Comments for Planning Application 21/0048/FUL

Application Number: 21/0048/FUL

Address: 1 Parson Street London NW4 1QD

Proposal: Demolition of existing building and construction of part three/part four storey mixed use building comprising 9 residential units and office floorspace at ground floor level. Associated amenity space, refuse storage, cycle parking and off-street parking

Proposed Rear Elevation

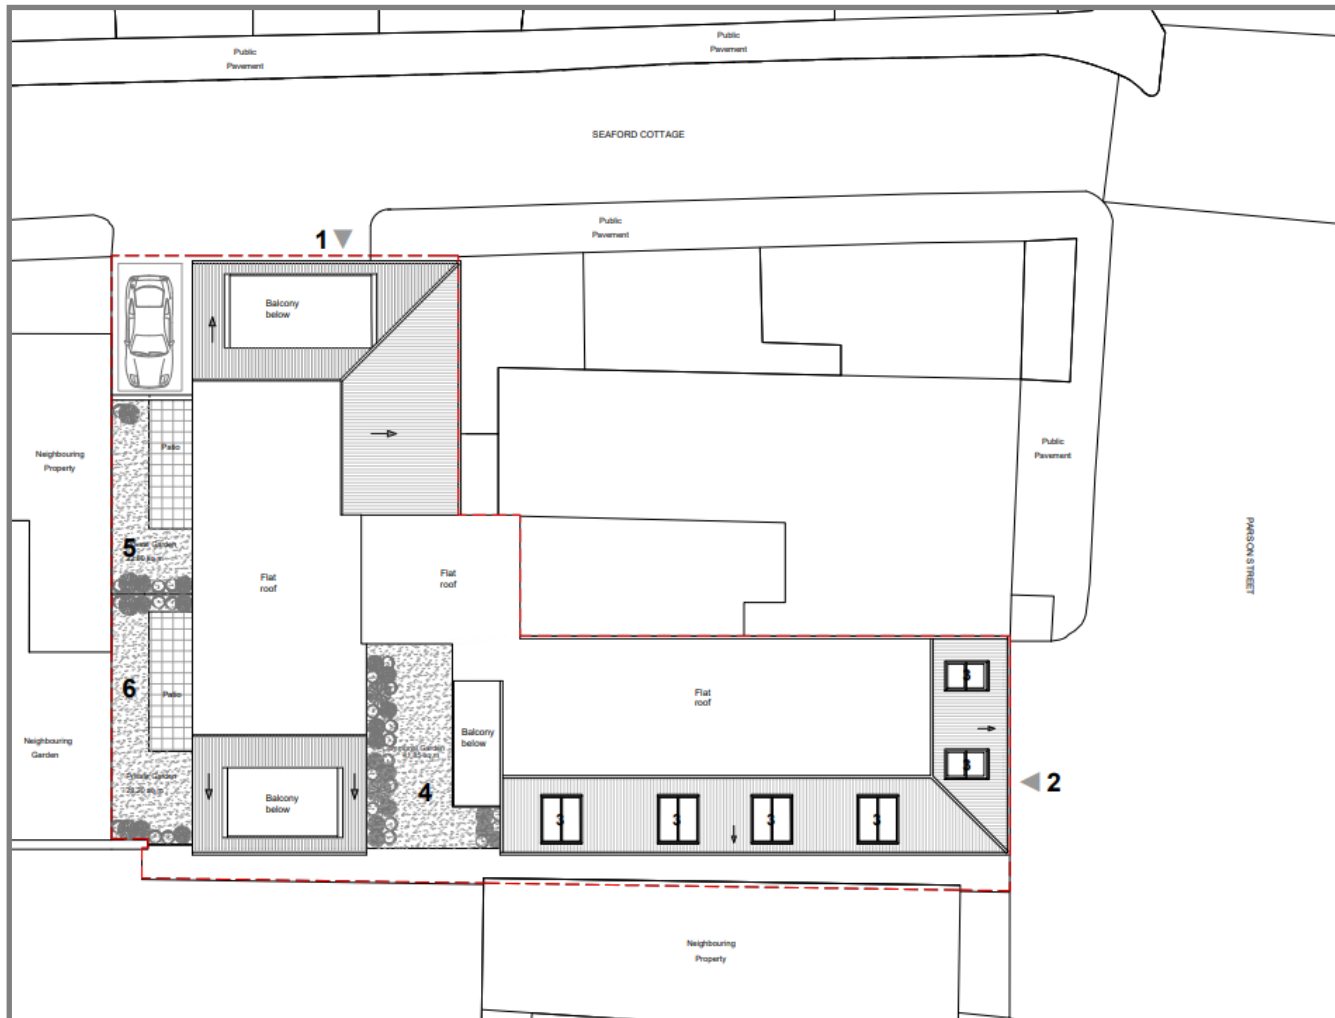
- The proposed rear elevation is a direct infringement on our garden and thus our privacy.

- The proposed rear elevation places a parking space and gardens next to our house. How will our

house wall be protected and will we be compensated in its use as part of the boundary for these elements?
